**From:**  
**Sent:** 06 January 2026 20:39  
**To:** DC Admin  
**Subject:** RE: Planning application 2025/60/92776/E Banks group development Eastfield HD88HB

I would be grateful if you would add these additional comments to my original objection and brought to the attention of the planning committee.

The transport assessment section 3.4 on cycling Accessibility is incorrect. It states that *“Cycling also has potential to substitute for short car trips, particularly those under 5 kilometres, and to form part of a longer journey by public transport” (Para 77)*

Figure 3-5 Cycle Network Map

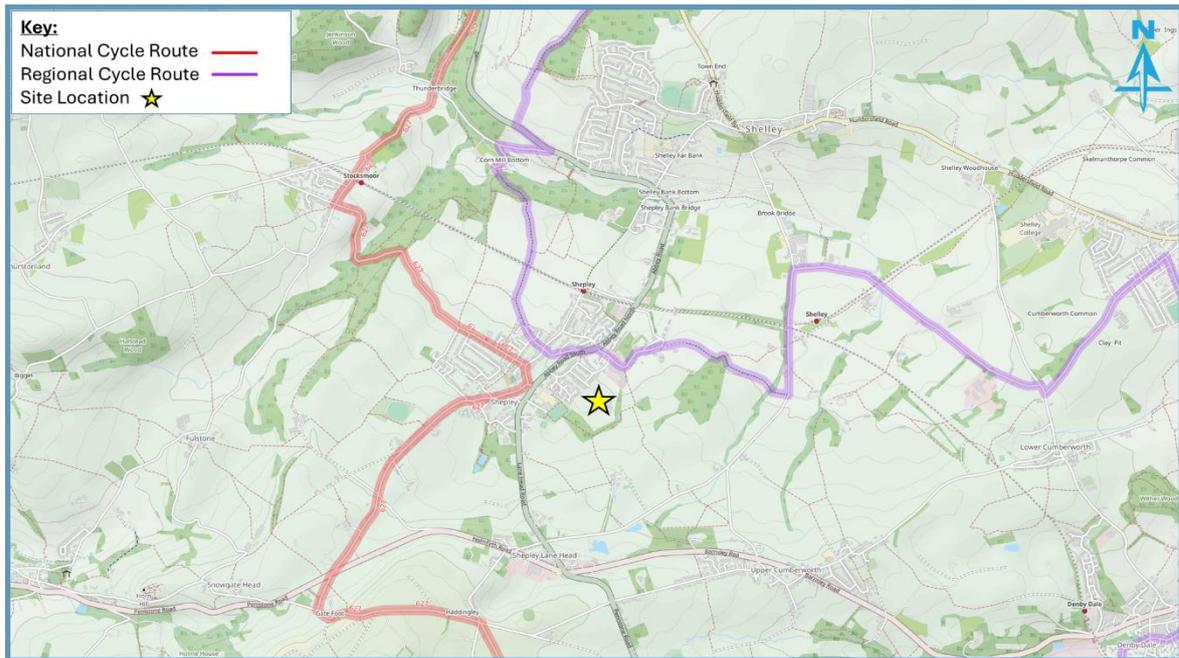
In support of this claim it offers National cycle route 627 and Regional route. The Regional route uses a bridle way that has a number of steep sections that are very muddy and difficult to ride along. The NCR uses dam hill to get to Stockmore which is a narrow steeply descending twisty road with an equally difficult ascent.

Abbey Road South is a steep ascent to Sovereign cross roads passing Car lane. Both have been the scene of many accidents in recent years and at least one fatality.

There are very few cycle lanes available locally and it is very unlikely that cycling could be seen as a viable alternative to a short car trip with the routes suggested.
